re: **Landscaping Plan Review - Block 22**
Wateridge Village Residential Development - Phase 1B - Block 22
1400 Hemlock Road - Ottawa

file: PG5345-MEMO.01 Revision 1

Landscaping Plan Review

L-01

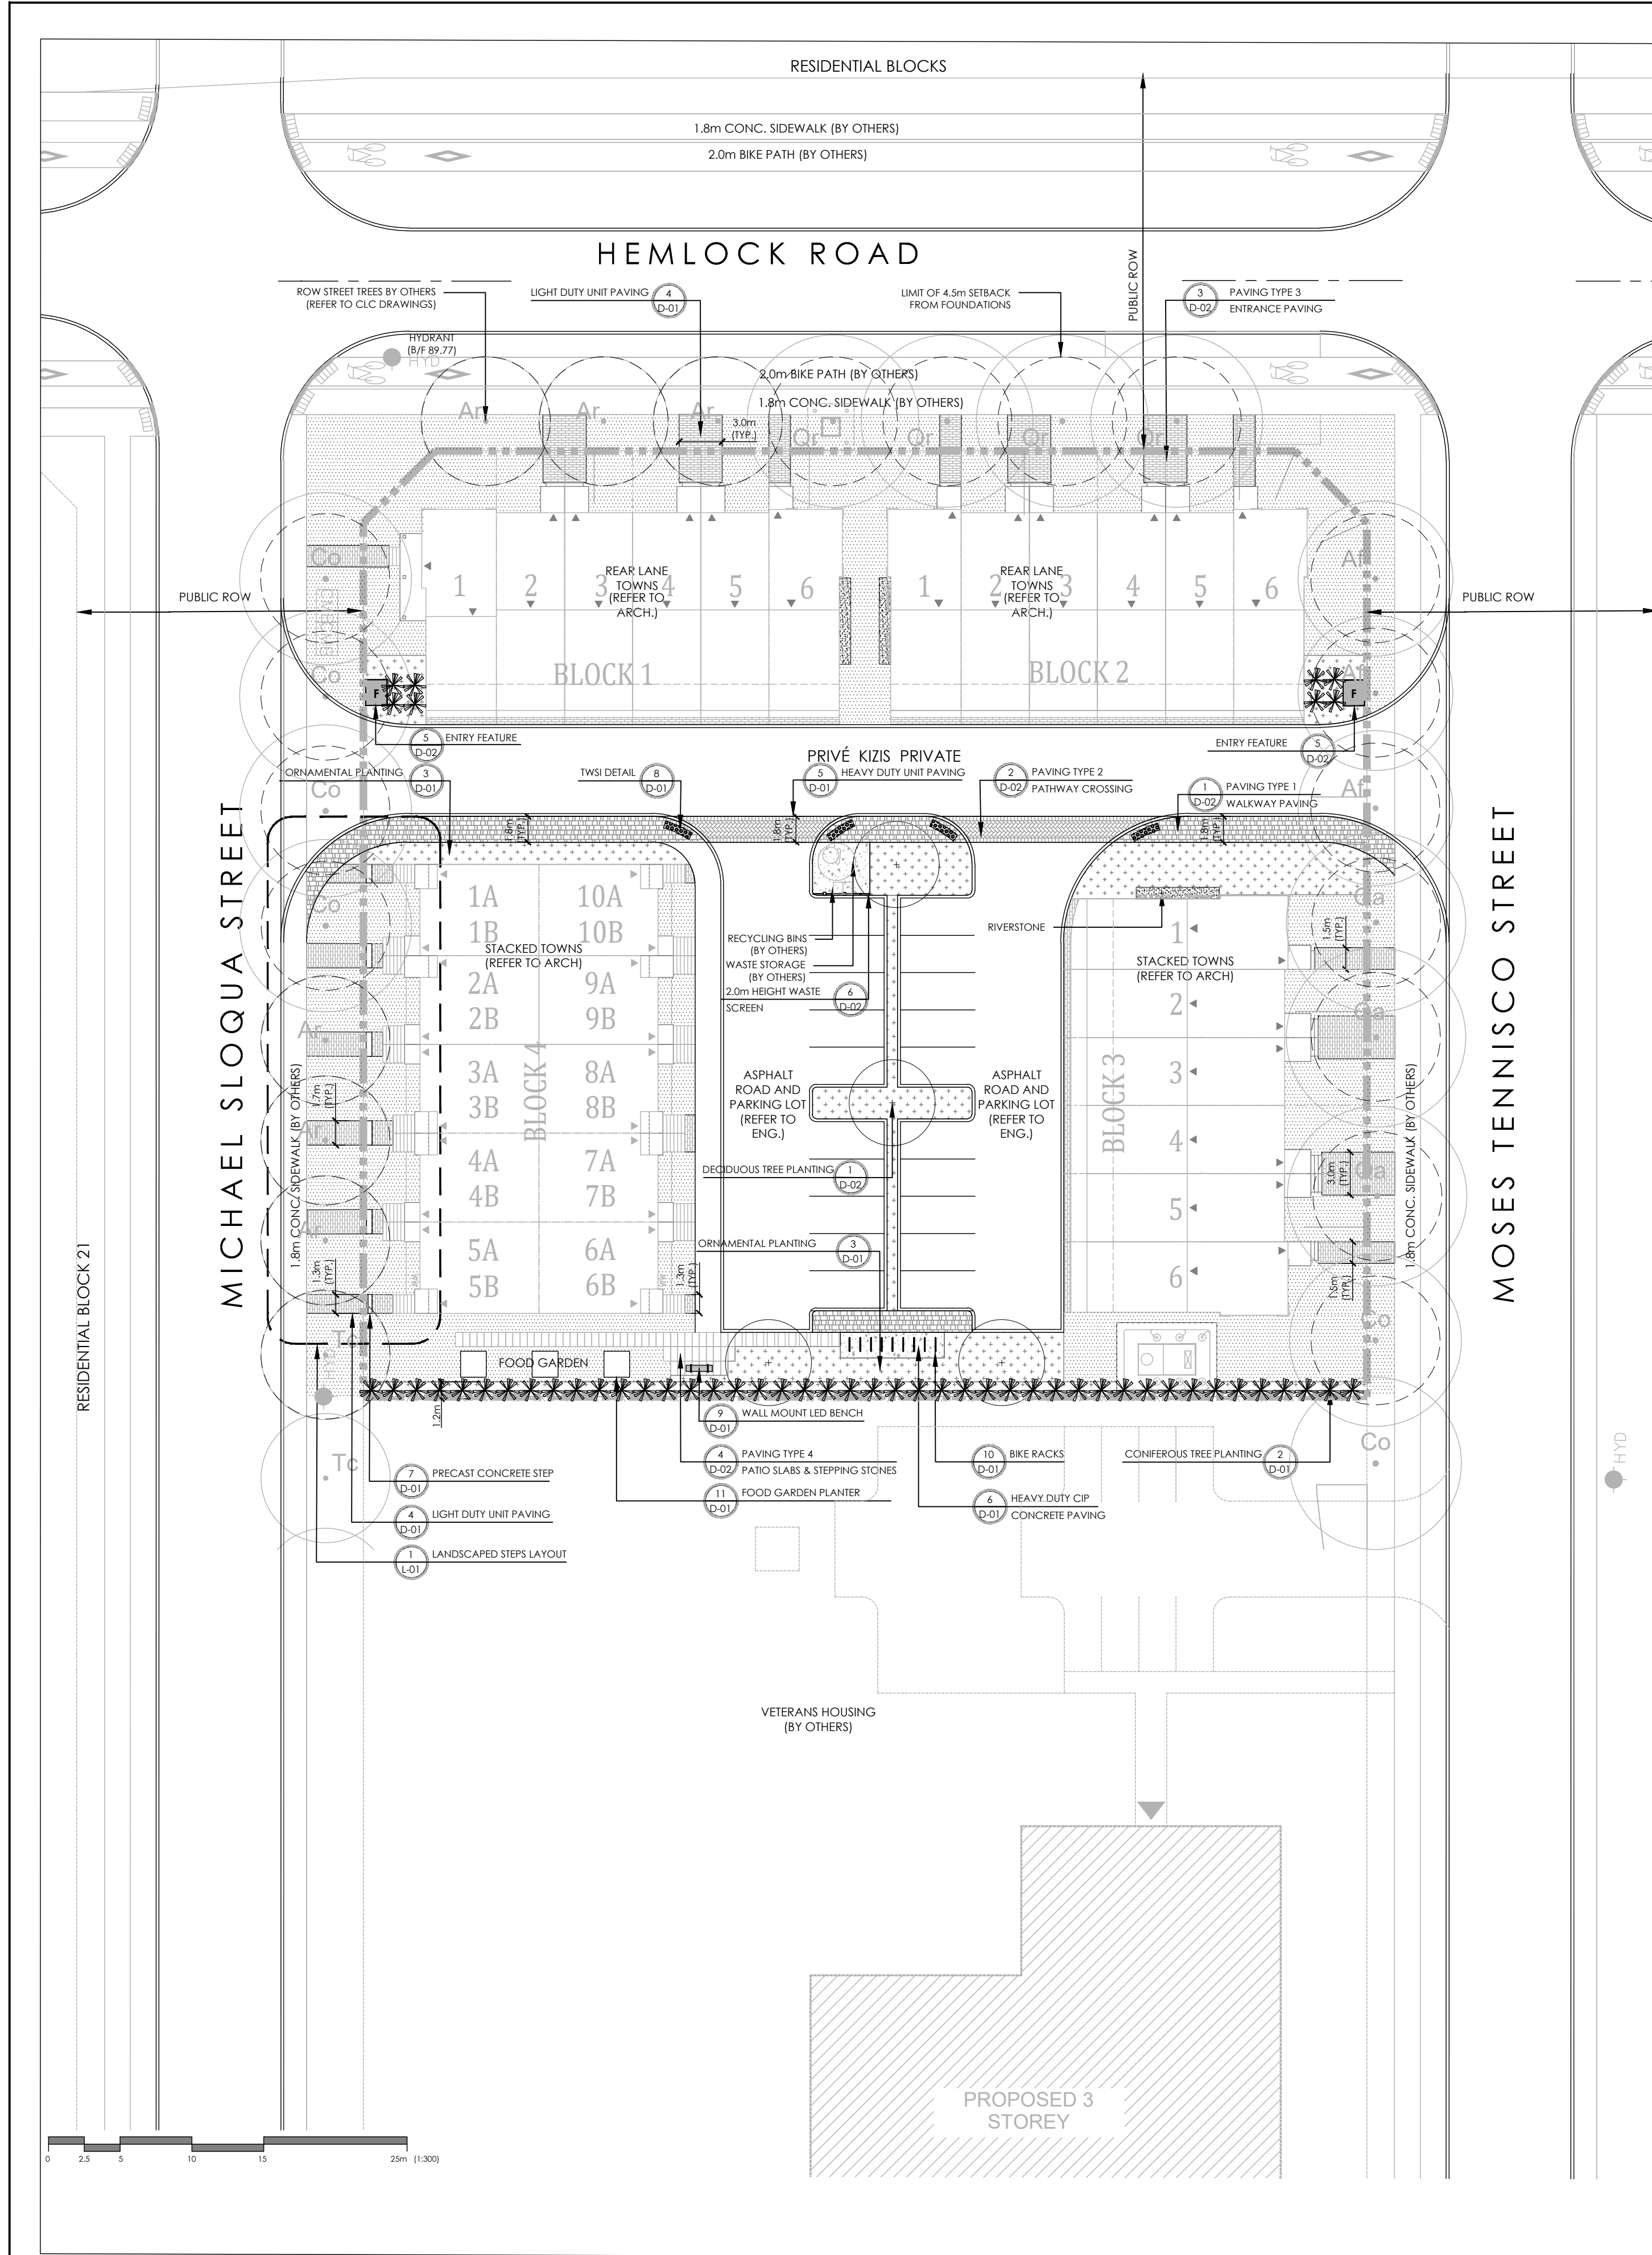
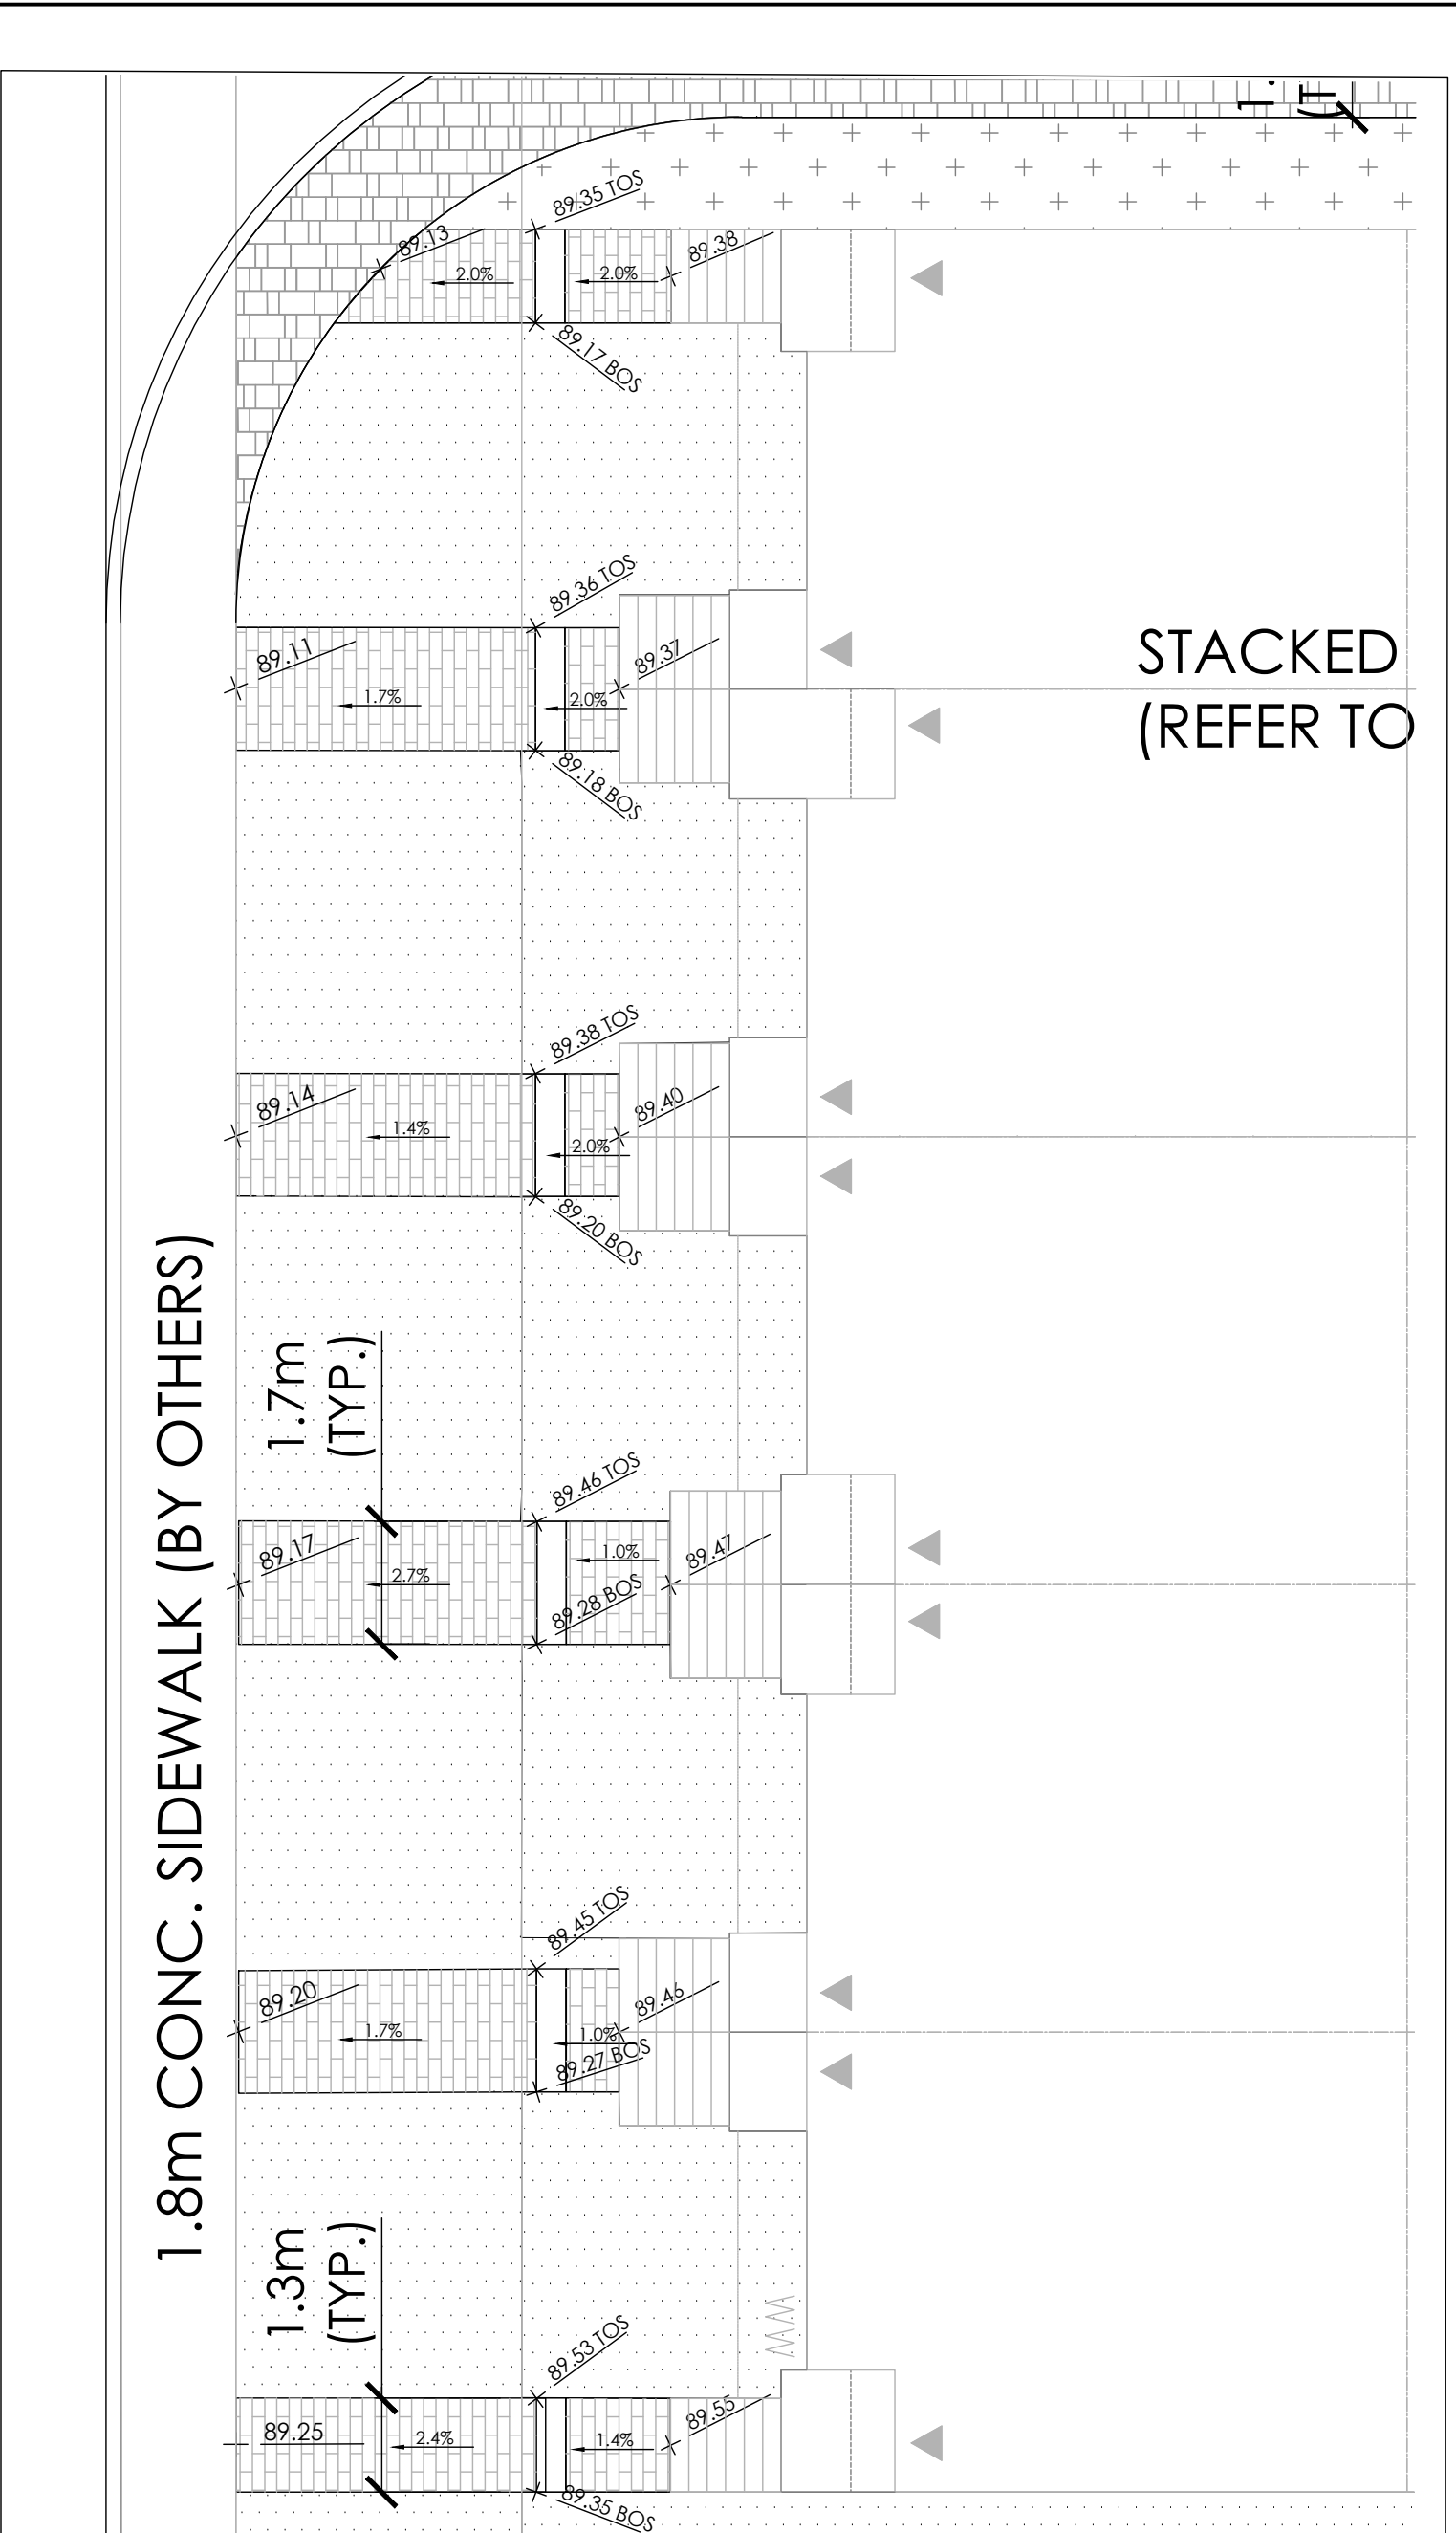
- ☐ The proposed trees should have a minimum setback of 4.5 m from the proposed foundation walls. Based on our review of the landscaping plan, a 4.5 m setback has been provided for all street trees, **with the exception of Block 2 - Unit 6**. It was noted that the 4.5 m setback intersected with the majority of stair and porch structures fronting onto a publicly owned road.

The landscaping architect should confirm that the tree species placed within 7.5 m of the foundation wall consist of small and medium size trees with a mature tree height less than or equal to 14 m. It is understood that the tree heights listed on the plan are the mature heights of these trees in natural conditions and not in city conditions.
